Our Ref: AL/1/19/HH

**Town & Country Planning Act 1990 (as amended)
Town & country Planning (Development Management Procedure) (England) Order 2015
Application for Planning Permission for Works or Extension to a Dwelling**

Development Steplift to the front door.
Location 29 Beechfield Park Hook Lane Aldingbourne

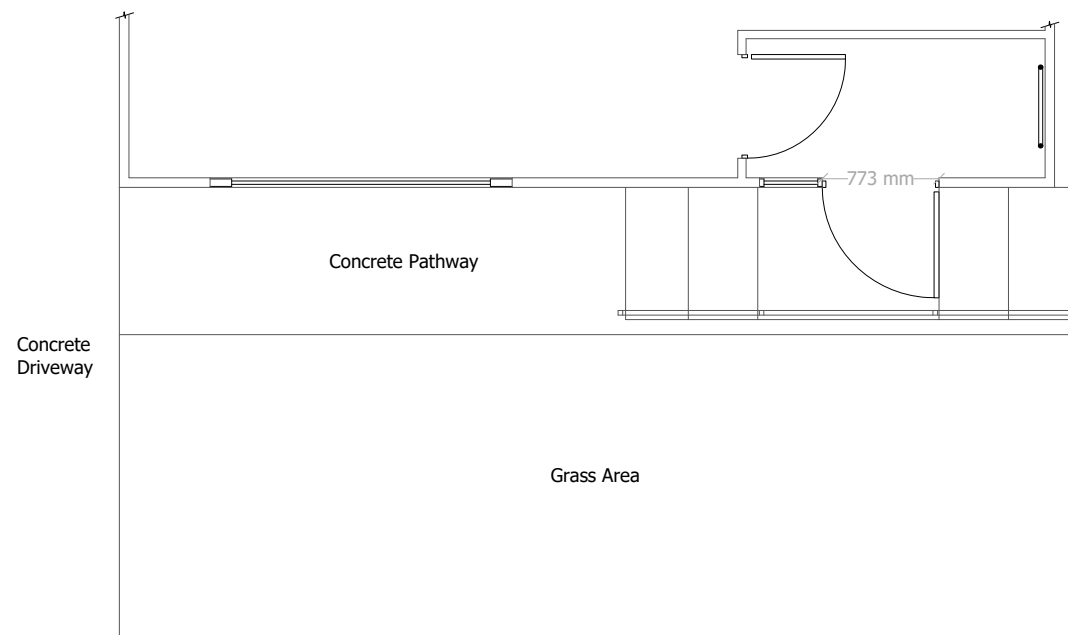
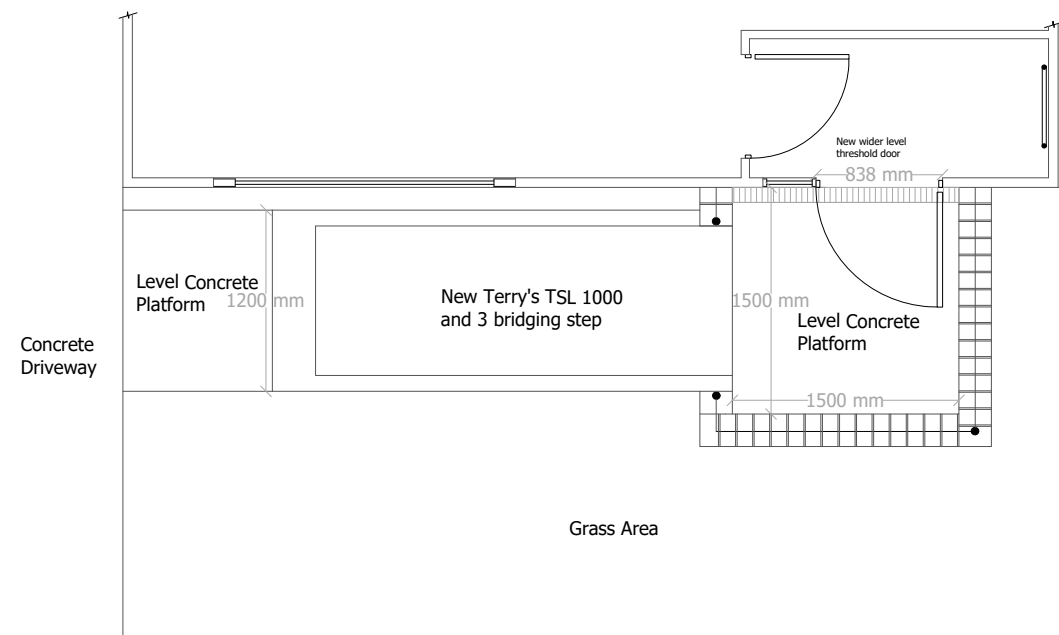
Block Plan: Please provide the other side dimension from the proposed steplift to the site boundary.
